**Re: Golf Course Rd. and Westside Blvd. TIS draft**  
Traffic Impact Study, HT#A12D008B2  
Report dated December 12, 2022  
Engineer's Stamp draft  
Via email [tbrown@tierrawestllc.com](mailto:tbrown@tierrawestllc.com)

The subject Traffic Impact Study received on December 15, 2022, has been reviewed by the City of Albuquerque Planning Development Transportation Section. The City has comments to be address in the next submittal.

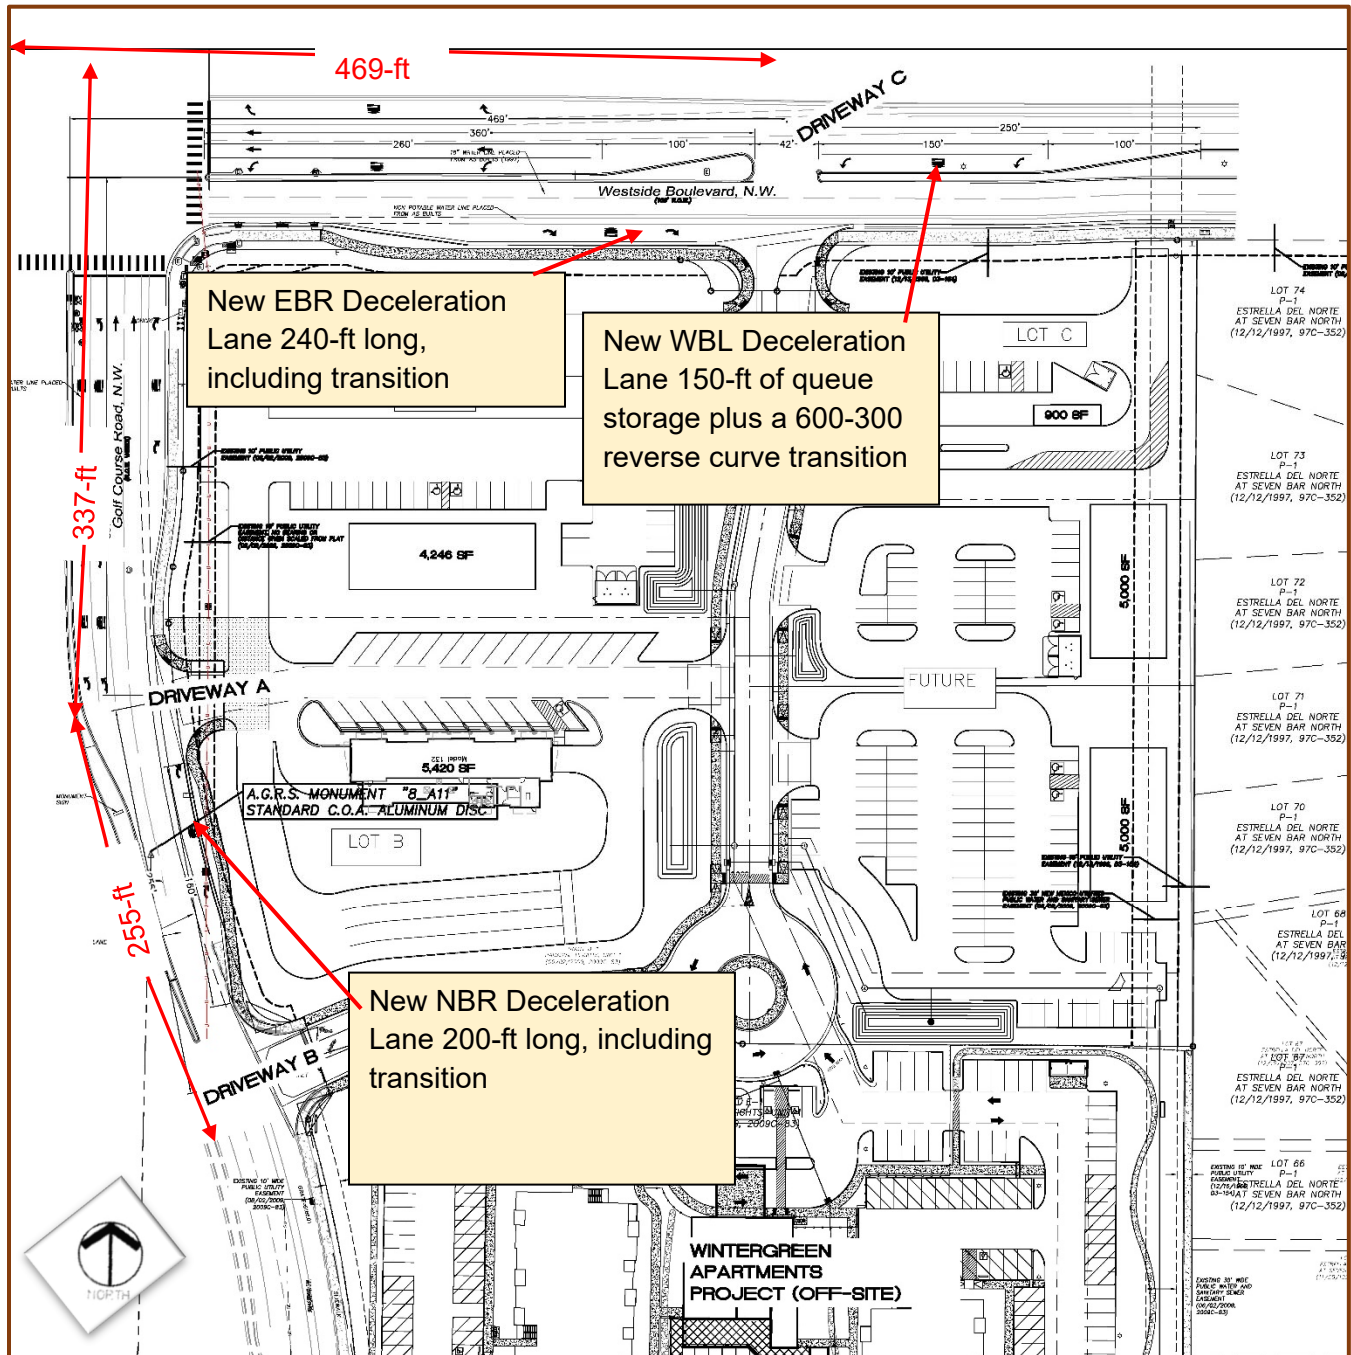
- The proposed accesses on Golf Course Rd. and Westside Blvd. are acceptable.
- Include a site plan with sufficient detail to be used as guidance in preparing the DRC workorder plans.
- Tierra West shall contact the NMDOT District 3 for guidance in modifying the median and adding a right-turn lane on Westside Blvd.
